Application for a non-material amendment following a grant of planning permission.

<input type="text" value="Erection of 1No dwelling and access (following demolition of two outbuildings)."/>	
Reference number:	<input type="text" value="DC/20/05180"/>
Date of decision	<input type="text" value="27/09/2021"/>

20.05/04 rev C and 20.05/03 rev D

20.05/04 rev D and 20.05/03 rev E

drawing
 Elevations as proposed.

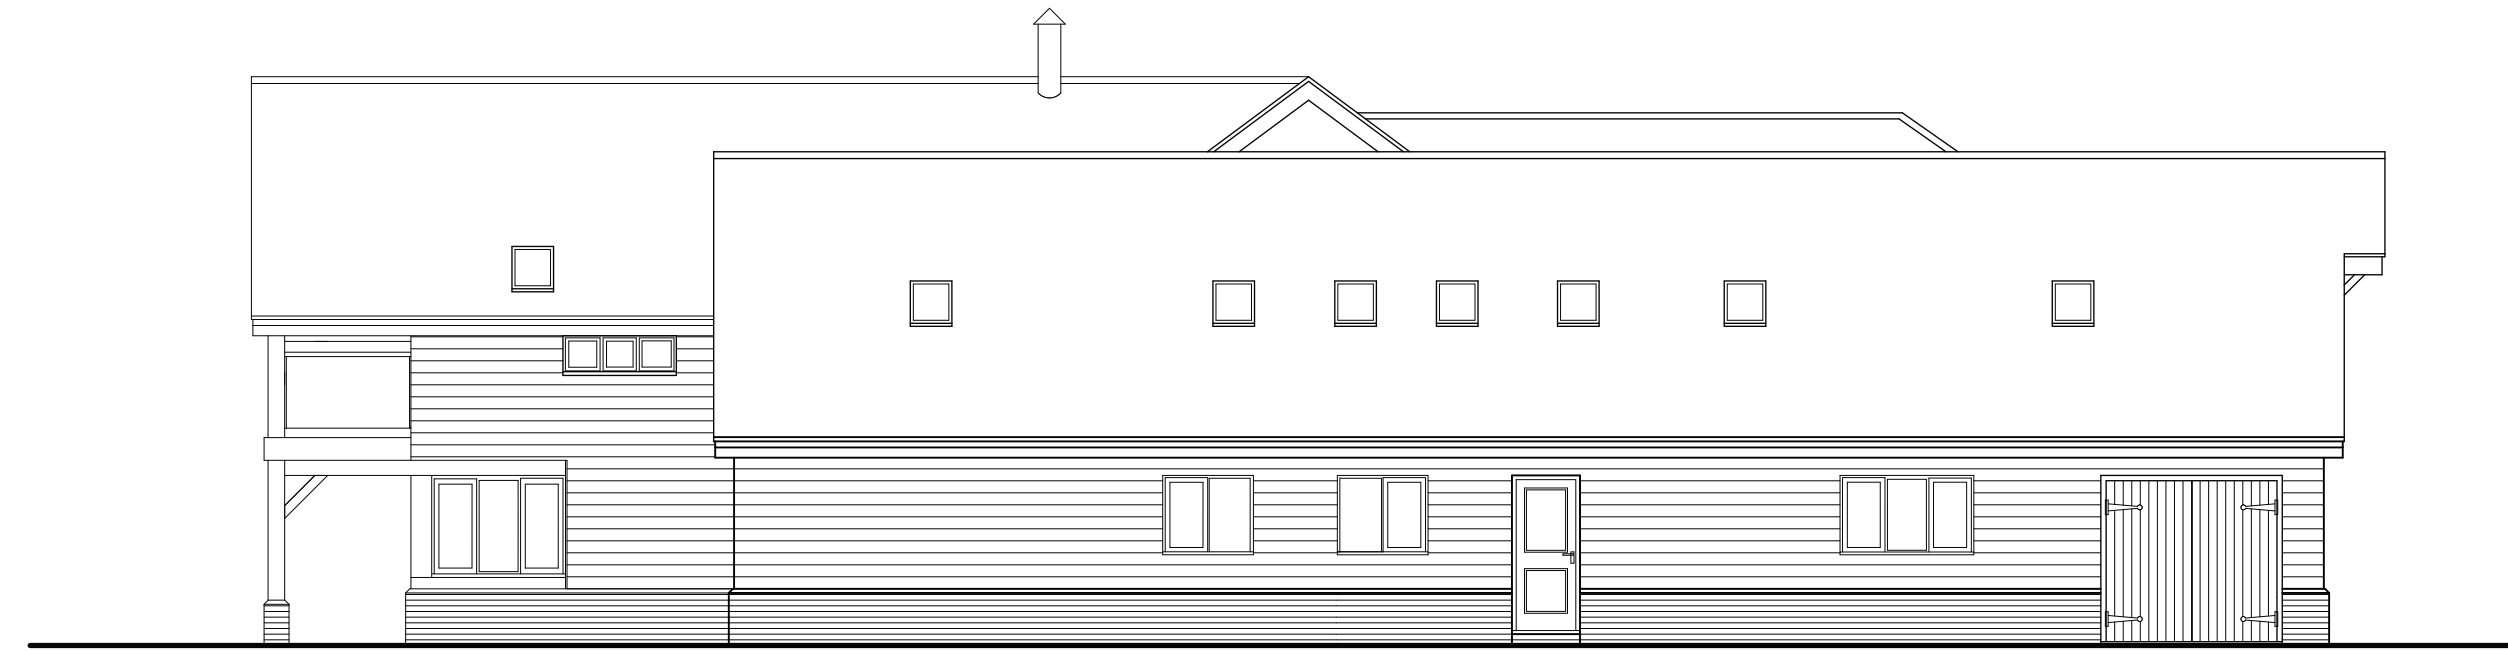
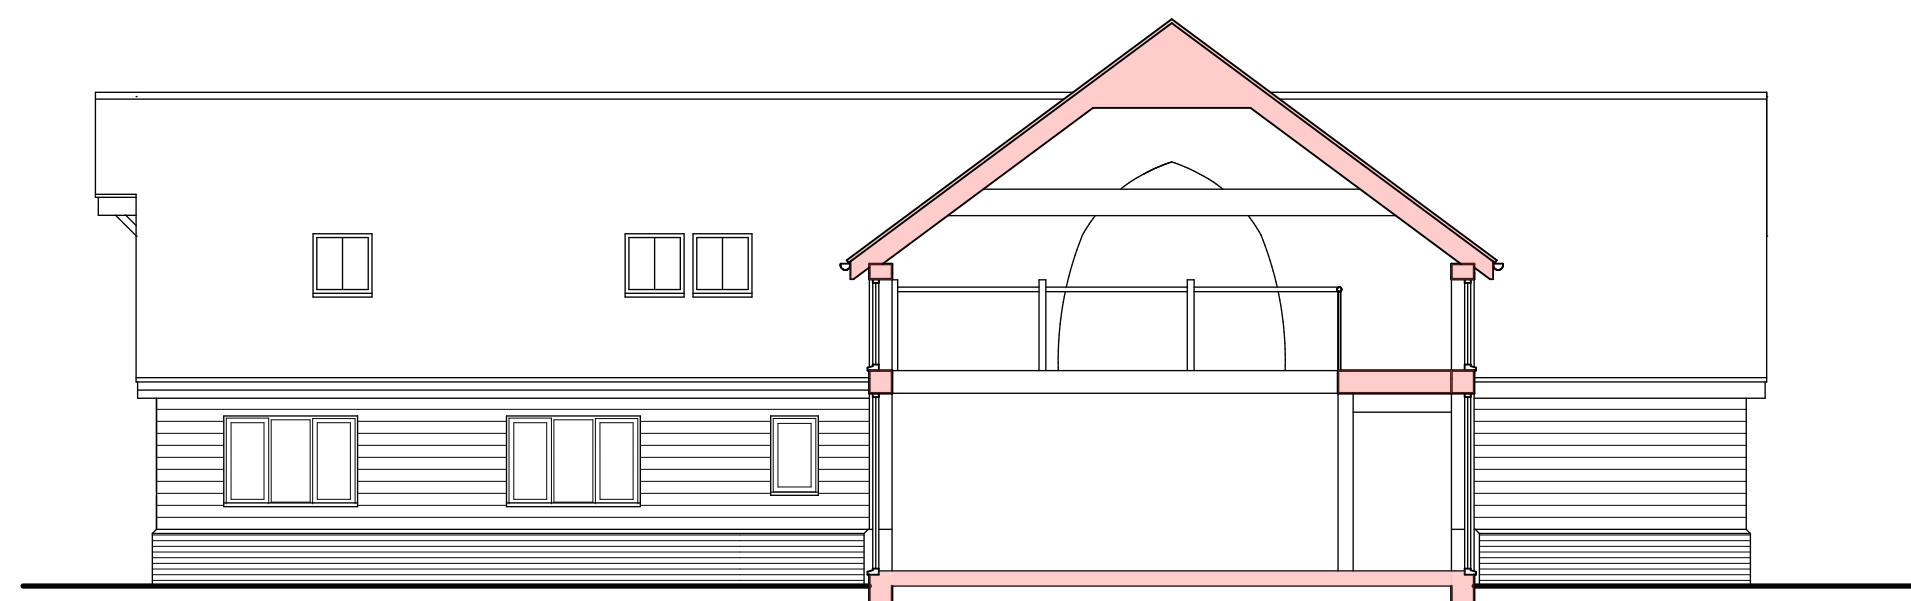
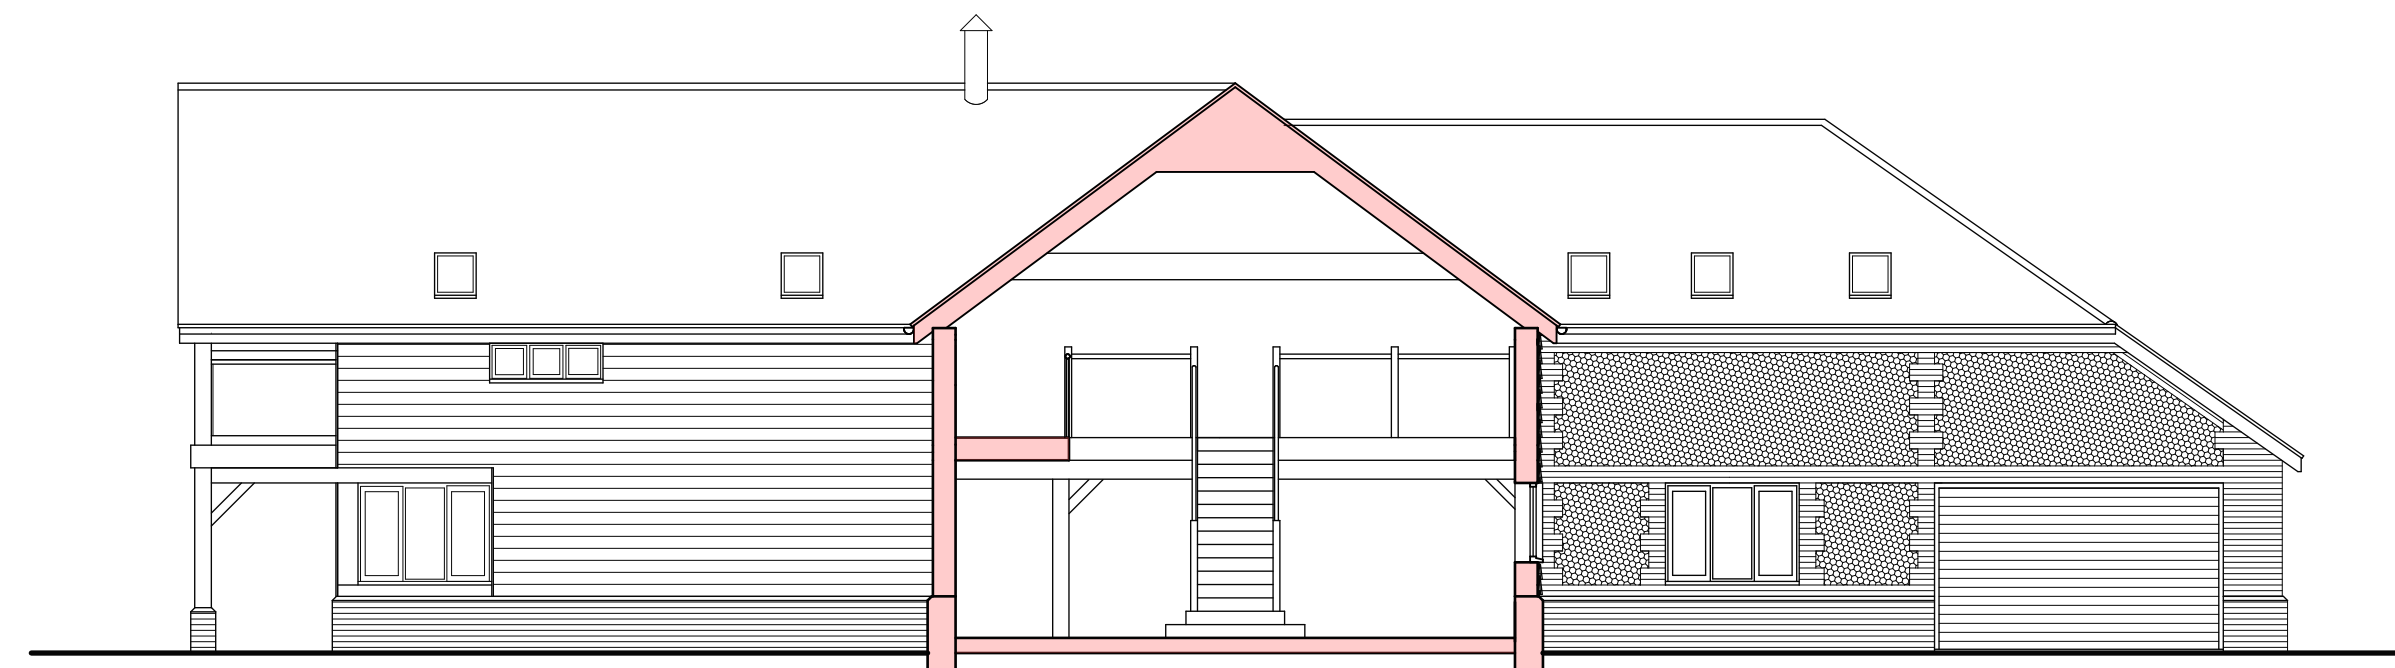
Internal layout has been amended to suit Clients requirements. Therefore various windows and door positions have been amended. The south east wing is now fully brick and flint to the walls.
